## KITTITAS COUNTY DEPARTMENT OF PUBLIC WORKS

### MEMORANDUM

SUBJECT: Akehurst Plat LP-08-00033 & Rezone RZ-08-00012

AKEHURST PLAT

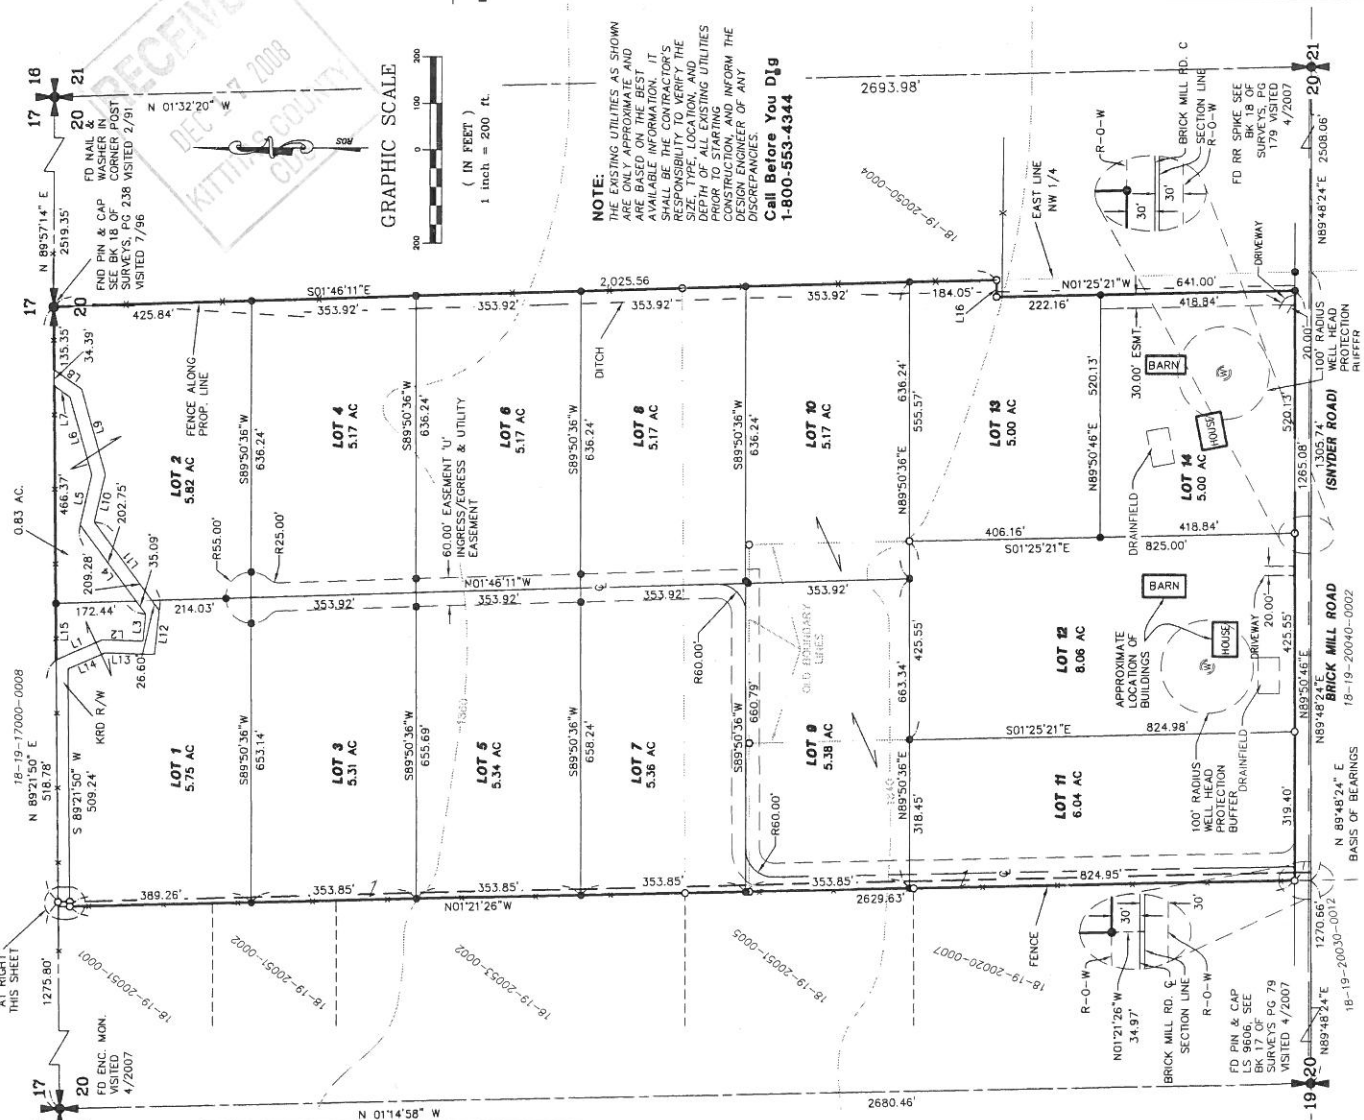
3. Private Road Improvements: Access from Brickmill Road to the cul-de-sac shall be constructed to meet or exceed the conditions of a Low-Density Private Road. See Kittitas County Road Standards, 9/6/05 edition.

- a. Access easements shall be a minimum of 60' wide. The roadway shall have a minimum width of 20', with 1' shoulders, for a total width of 22'.
  - b. Minimum centerline radius will be 60'.

4. Cul-de-Sac: A cul-de-sac turn-around having an outside right-of-way or easement diameter of at least 110 feet shall be constructed at the closed end of all dead-end roads serving 3 or more lots. The driving surface shall be at least 96 feet in diameter. Cul-de-sacs must also conform to the requirements specified by the 2006 International Fire Code. Contact the Fire Marshal regarding any additional cul-de-sac requirements.

5. Access: Access to Lots 1-11 is allowed in the proposed location by Road Variance 08-12. Access to Lot 12 shall be a single-use driveway in the existing location. Access to Lots 13 and 14 shall be a joint-use driveway in the existing location.
